ADDENDUM TO PLANNING RATIONALE – 1531 STITTSVILLE MAIN STREET

Huntington Properties
1306 Wellington Street West Suite 200
Ottawa, ON
K1Y 3B2

July 29, 2019

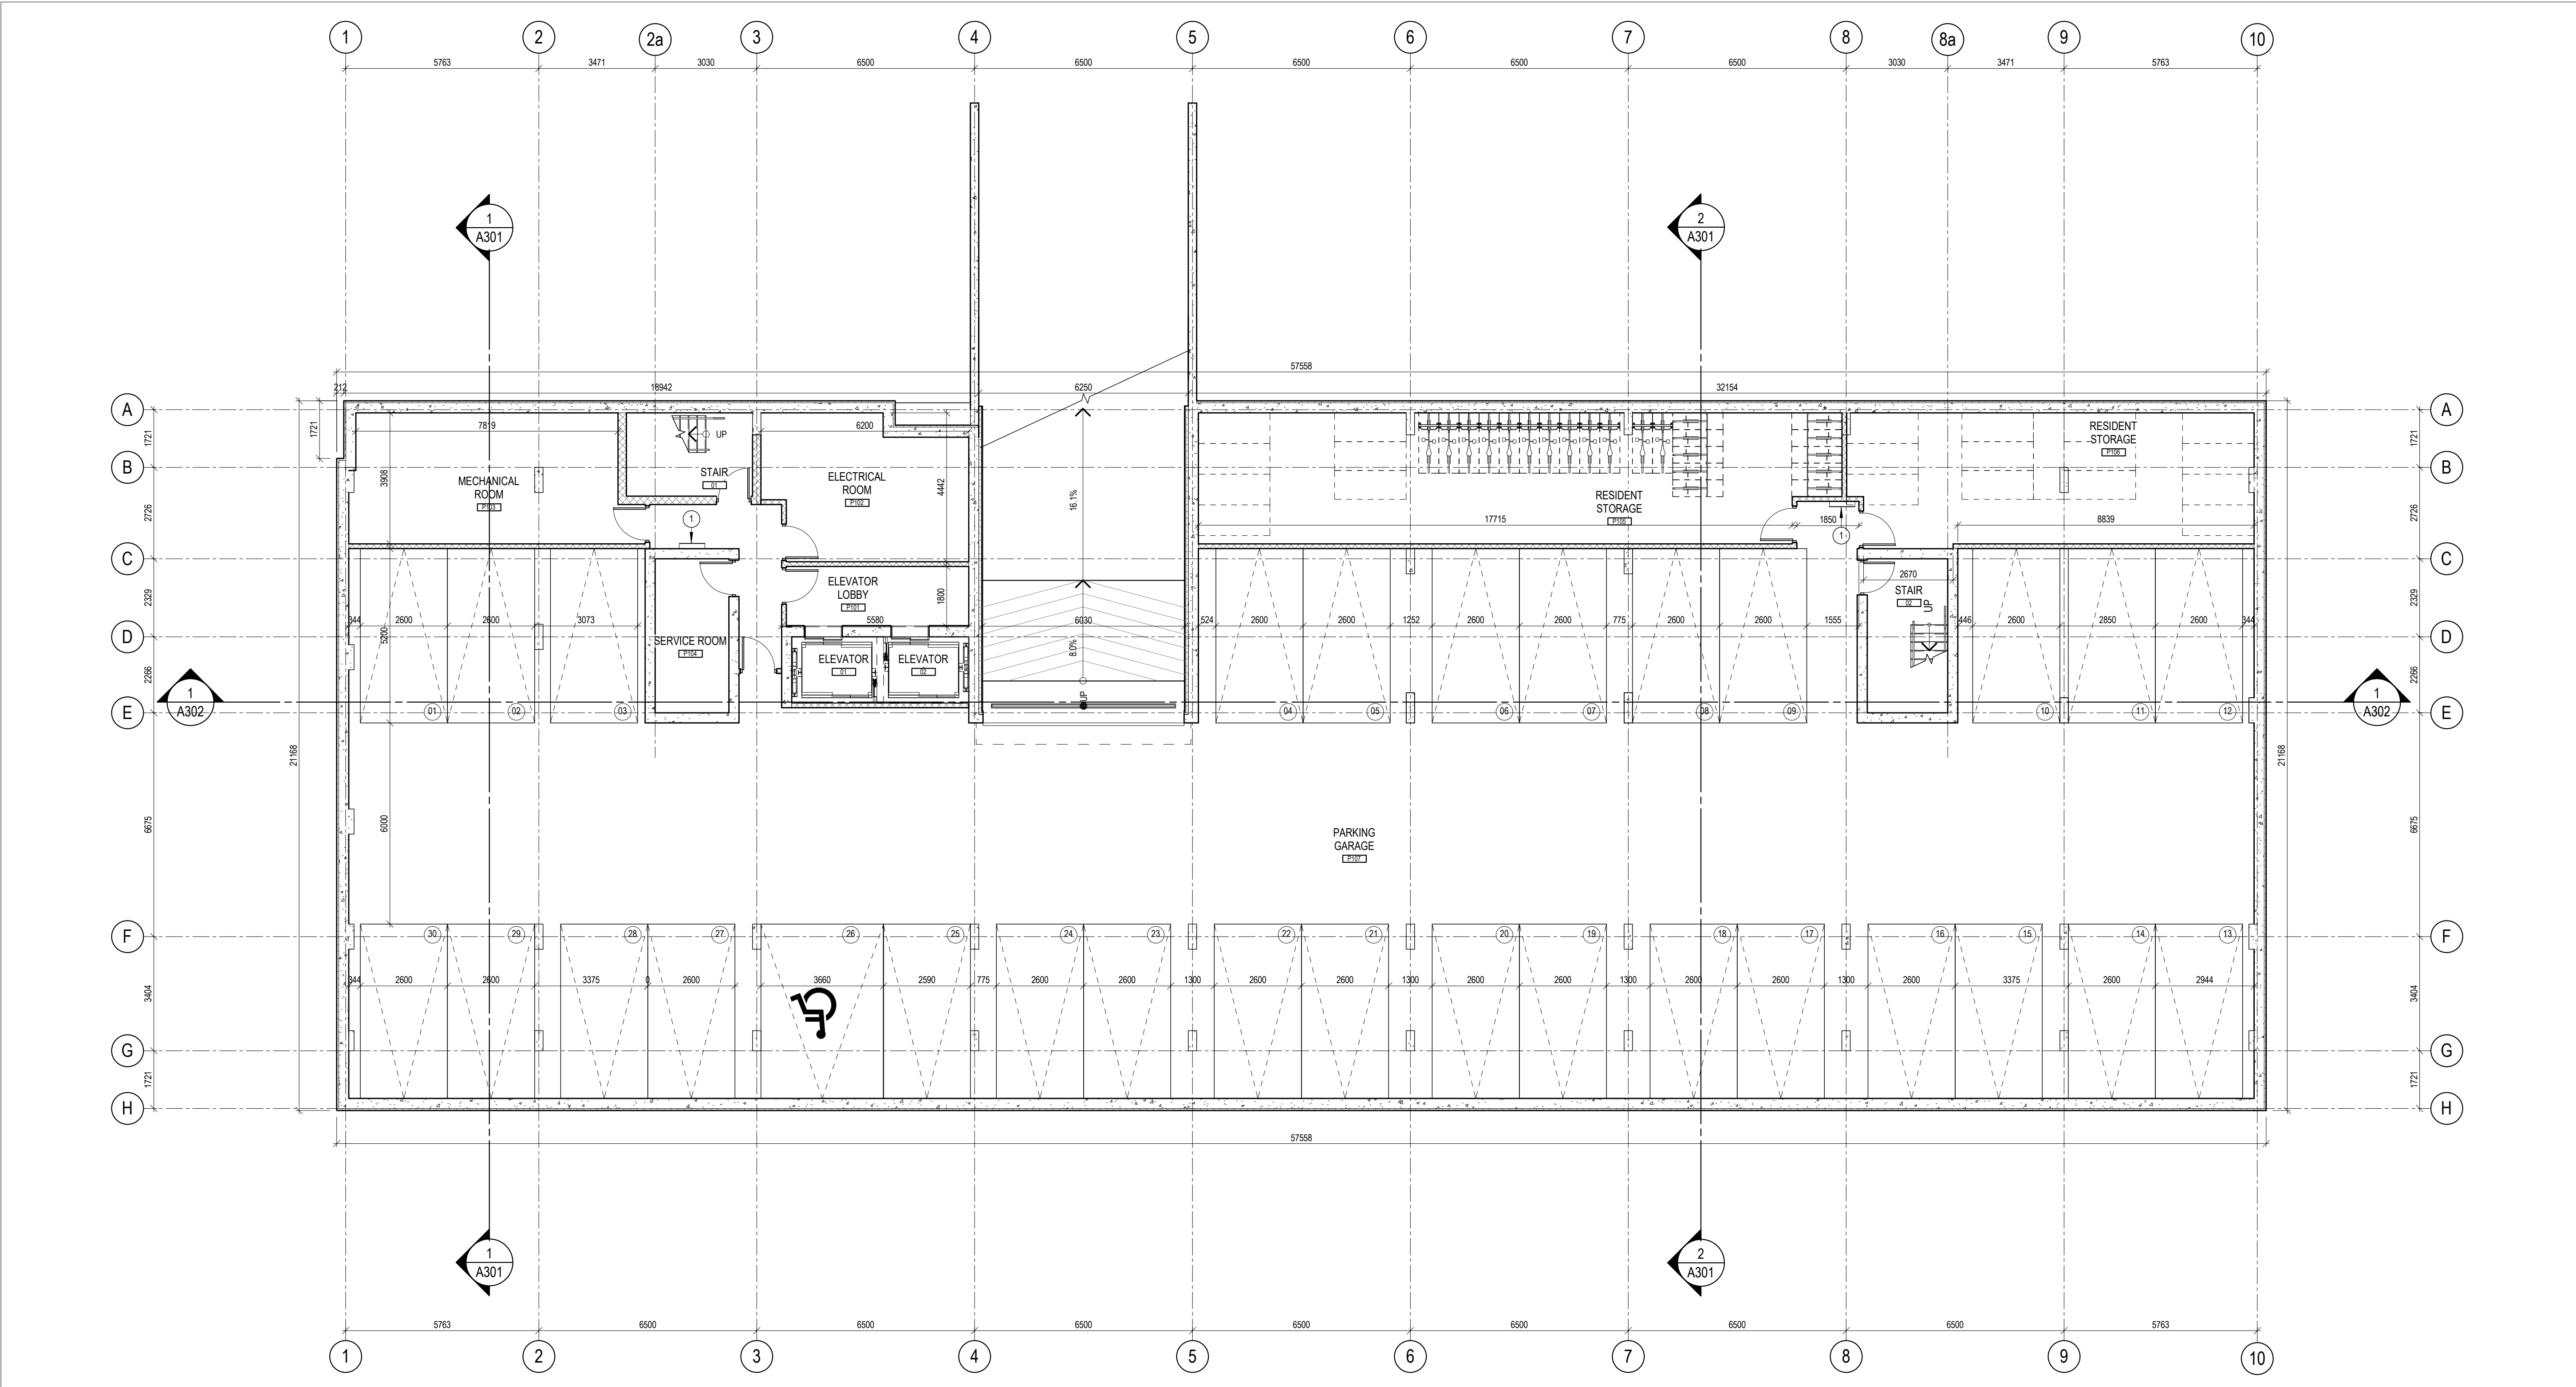
- / **Current does not meet Section 109 (1) (b) – no person may park in a required and provided corner side yard (Orville).**
- / Noted. Parking has been relocated away from the provided corner side yard along Orville Street.

- / **Current does not meet Table 110 (a) – 3m landscaped buffer required for parking lot abutting a street (Orville).**
- / Noted. The landscape buffer has been increased, providing the required 3m from the property line.

- / **Current does not meet Table 110 (b) – 1.5m landscaped buffer required for parking lot not abutting a street (south boundary).**
- / Noted. The landscape buffer has been increased to 1.6m to meet the requirements of the Zoning By-law

- / **Currently does not meet Clause 198(9)(f)(iv) – any part of a building above 7.5m, for which a minimum front yard setback of 2m must be provided**

- / Noted. The required front yard setback has been provided.
- / **The current parking calculation shows 25 surface parking spaces and 34 underground parking spaces and does not add up to the required 62 spaces for the mixed-use building. Please clarify.**

- / Parking space rates have been adjusted, a total of 67 parking spaces is now being provided.
- / **Revise bicycle parking rate to include retail use at 1 per 250 sq m of gfa.**

- / Noted. Bicycle parking has been revised, 30 spaces are being provided.
- / **Include retail gfa by unit in statistics and zoning information block.**

- / Noted. Changes reflected in Plans
- / **Label building height on site plan and include in information block.**
- / Noted. Changes reflected in Plans
- / **Label corner side yard setback for townhomes on site plan.**

- / Noted. Changes reflected in Plans. Townhomes, no longer included in proposal.
- / **Proposed outdoor commercial patio space should be labeled on the site plan.**

- / Noted. Changes reflected in Plans
